Your Ref: **32111000**
Our Ref: **G pre00220/2019**
(Please quote in all related correspondence)

06 July 2020

Re: Scoping Document for proposed replacement of 7 manned level crossings between Limerick Junction and Cork City on the Dublin-Cork Railway line.

| Project | Cork Line Level Crossing Project | Drawing | Interpretations M2-M3 XC215 (Shinanagh Townland), Co. Cork | | |

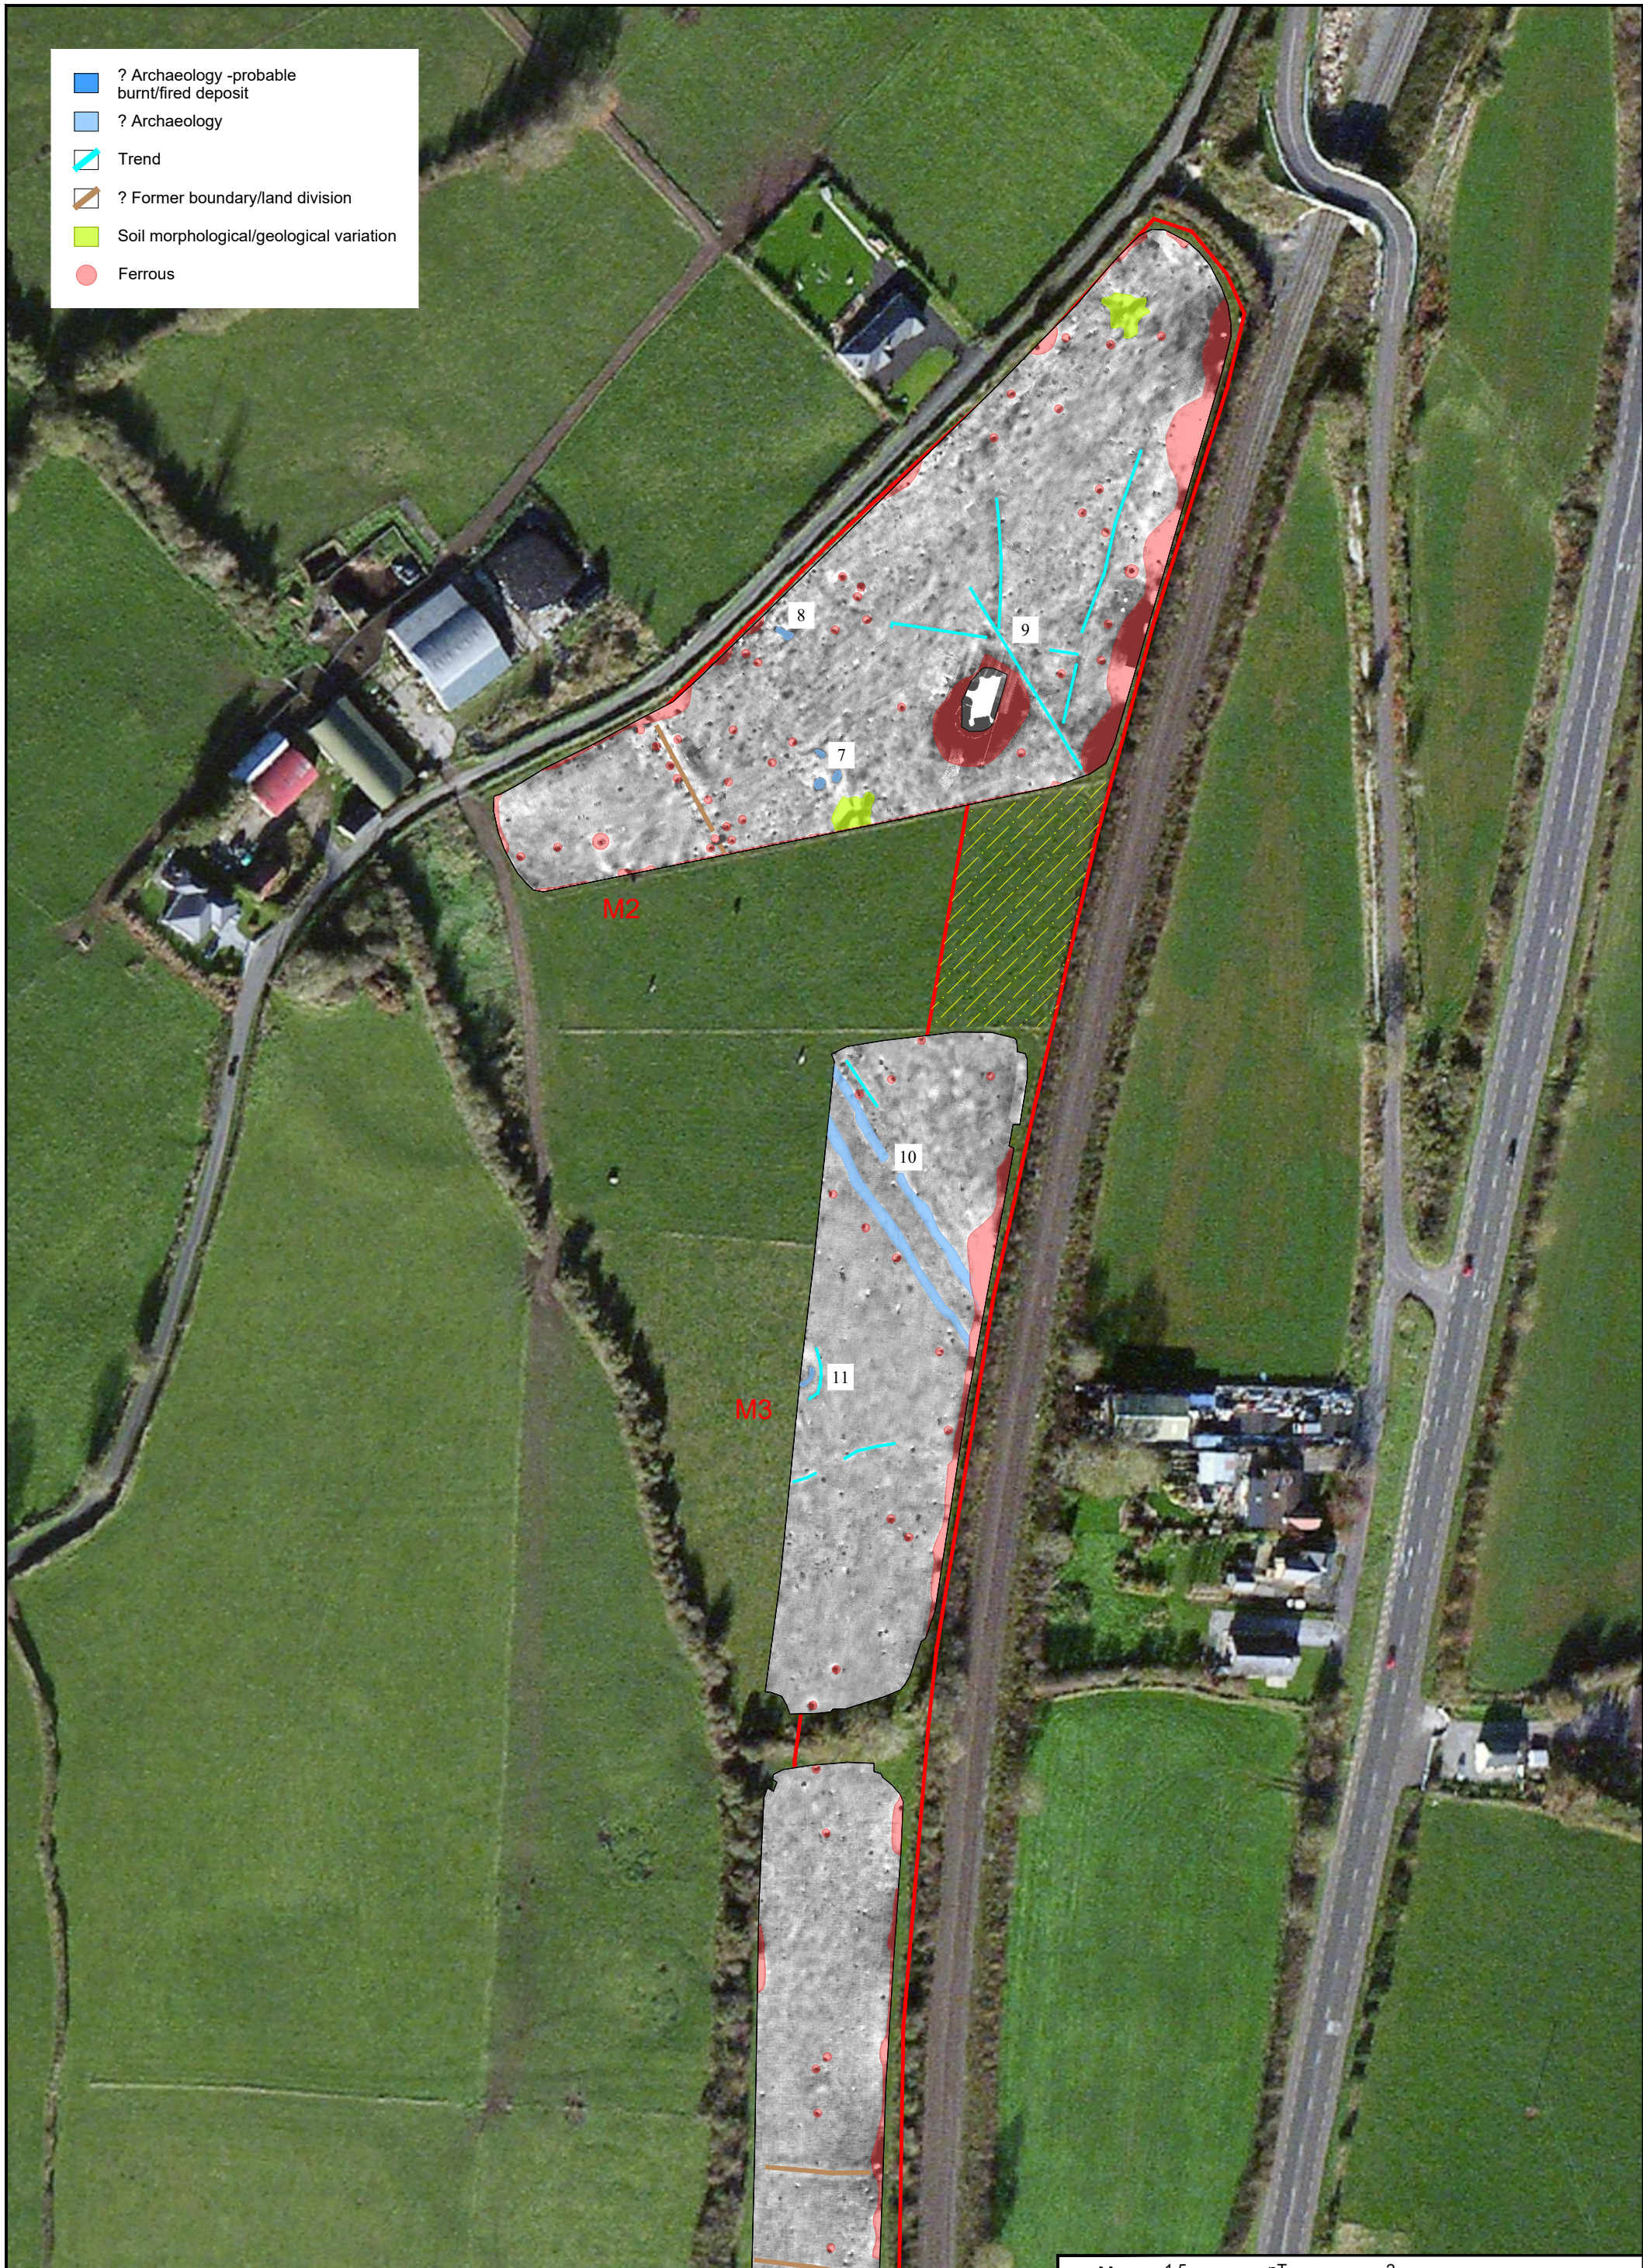
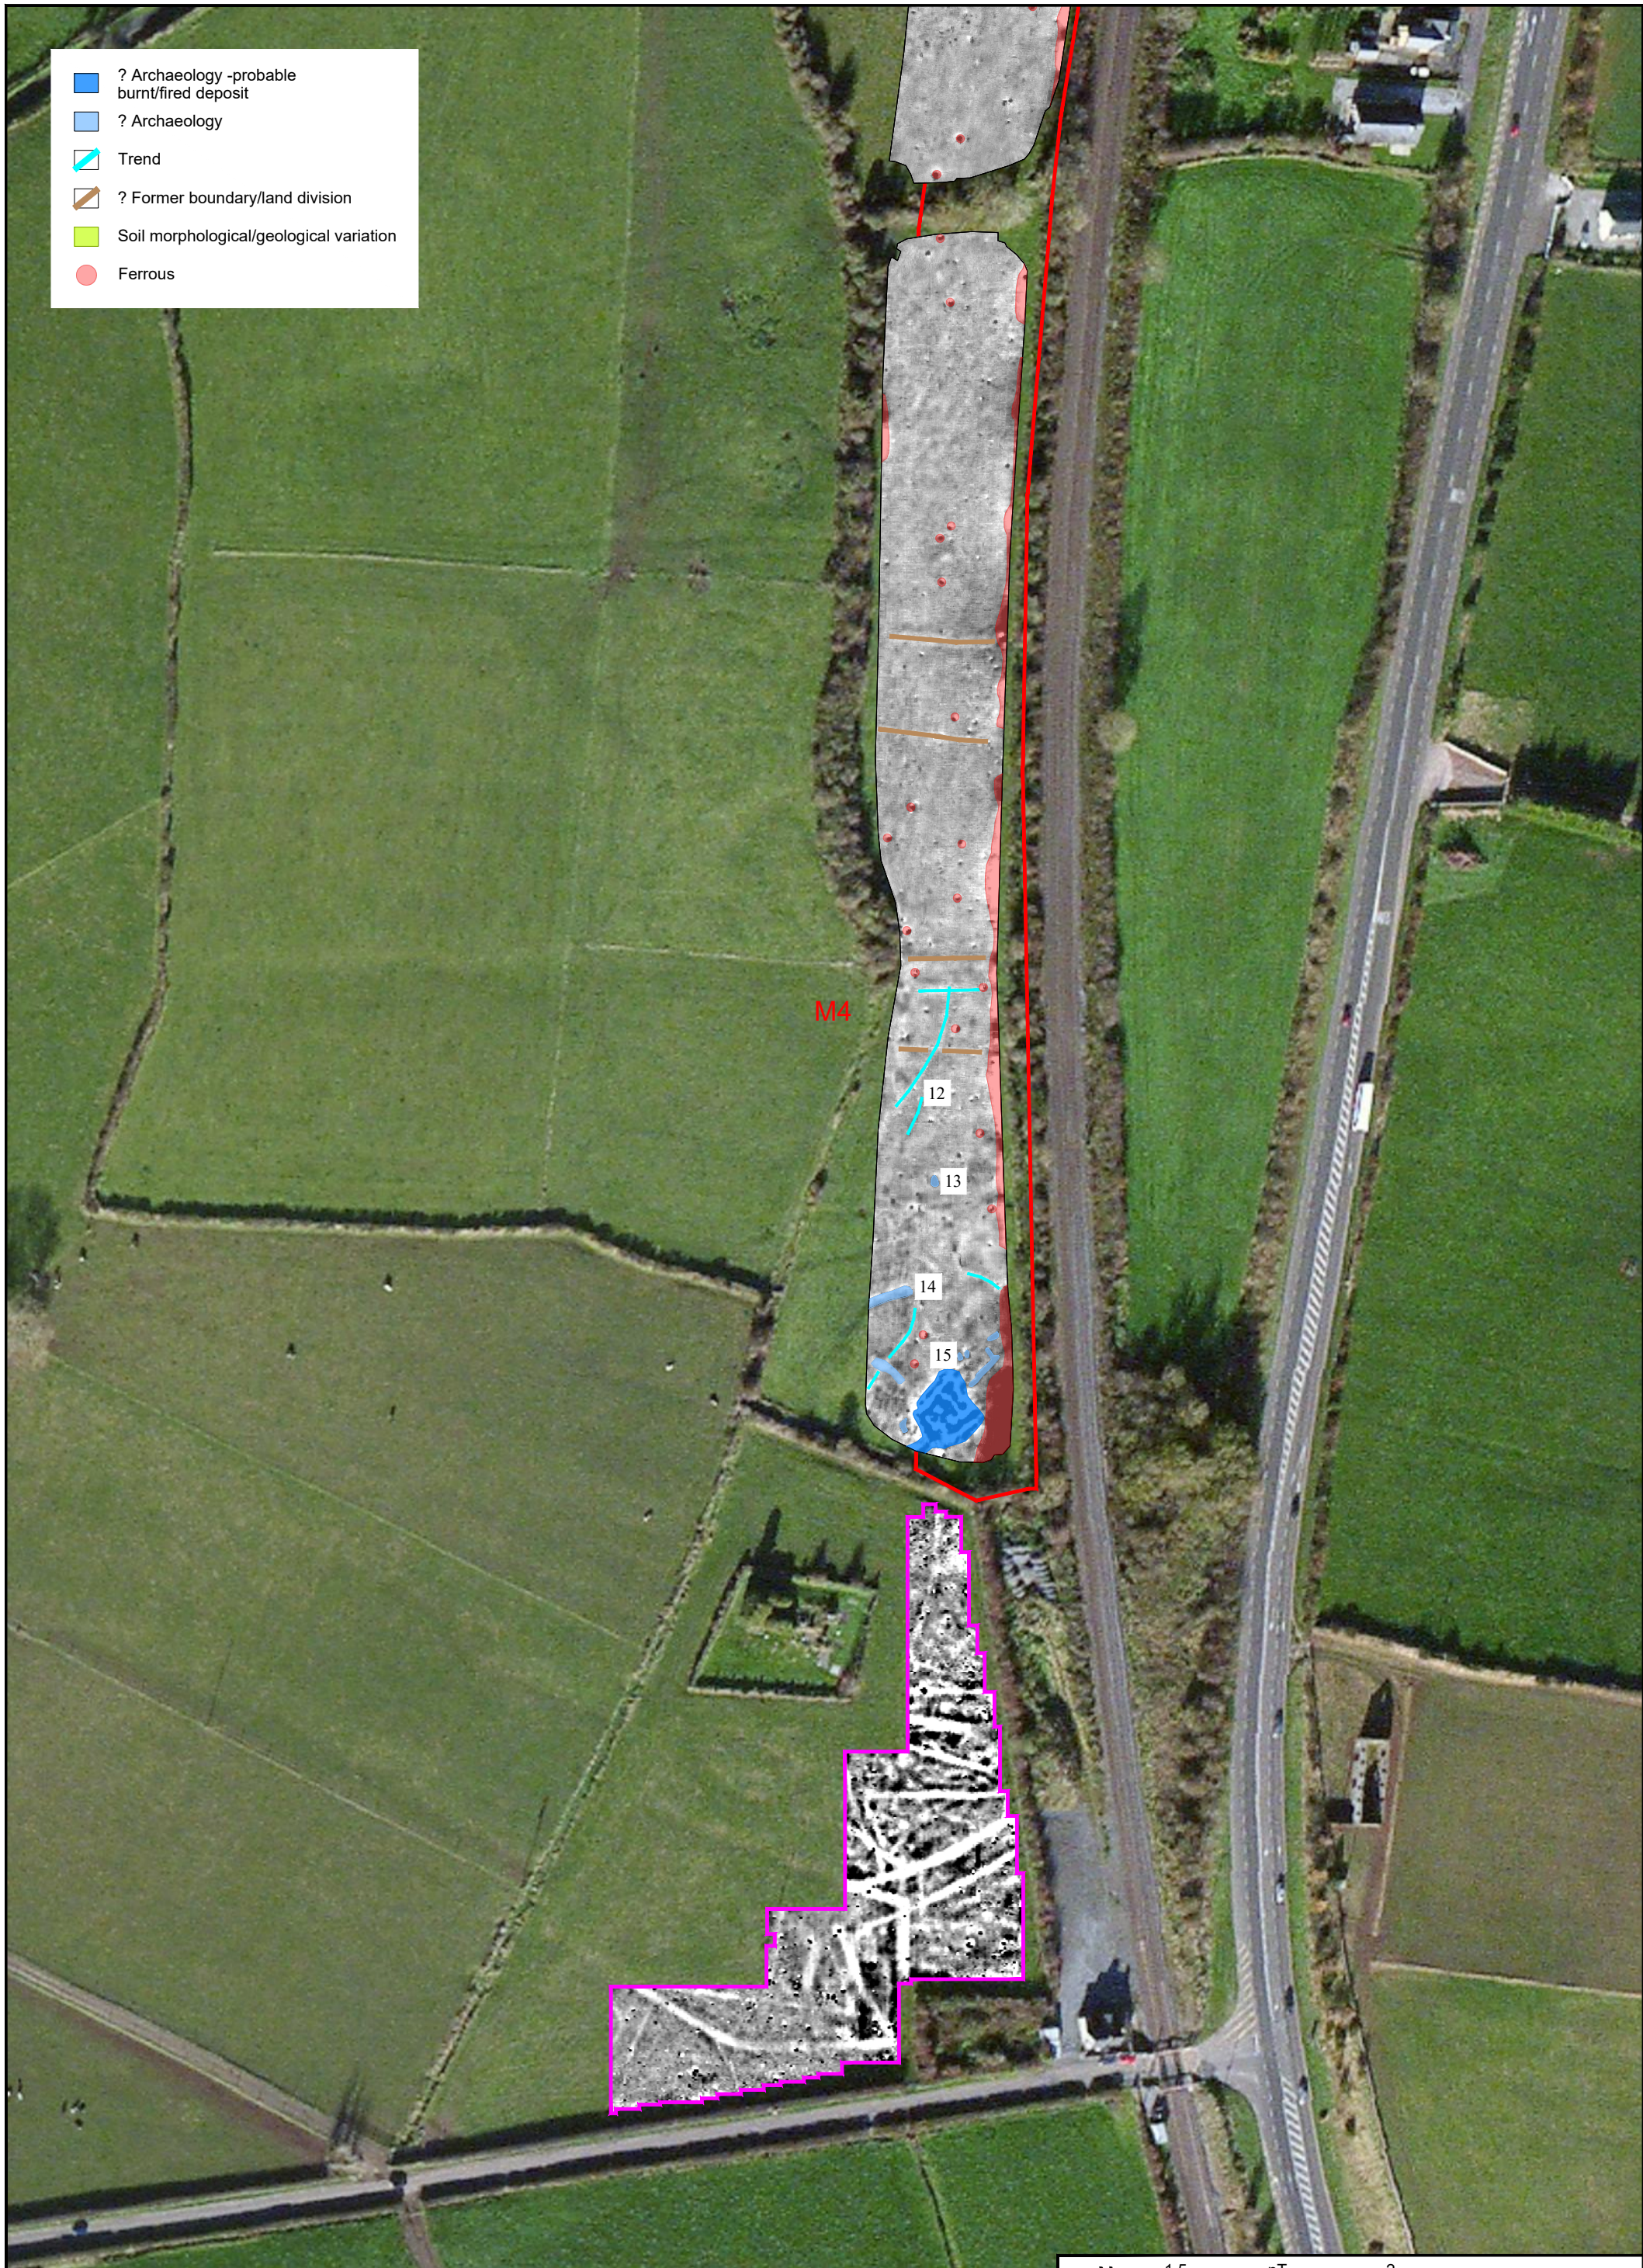
Report 20R0016 Shinanagh/Imphrick has recorded extensive and possibly archaeologically significant anomalies to the E/SE/S of Recorded Monument CO007-120(001-/002) *Church and graveyard*. Geophysics to the north of this monument has recorded a circular enclosure with extensive and possibly significant features within it – possibly representing a hut-site/souterrain/area of burning. There are also a number of features/low earthworks surrounding the enclosure itself.

A site inspection carried out on 02-07-2020 revealed that the earthworks in the vicinity of CO007-120, in addition to the newly recorded enclosure and its' associated features, all have surface expression at present ground level. Furthermore, the enclosure is clearly

visible as an upstanding scarped monument ranging in height from c. 40-70/80cm enclosing an area approximately 50/60m in diameter. Archaeological mitigation with regard to these monuments/features is also outlined below.

3. Given the extensive and possibly significant archaeological earthworks/features, including a newly recorded upstanding enclosure, at Shinanagh/Imprick, a programme of targeted archaeological test excavation is required. This will establish the location, nature and extent of archaeological features/deposits revealed during geophysical survey and field survey. In particular the nature of the earthworks to the E/SE/S of RMP CO007-120--- needs to be established in tandem with the newly recorded enclosure and its' associated features.
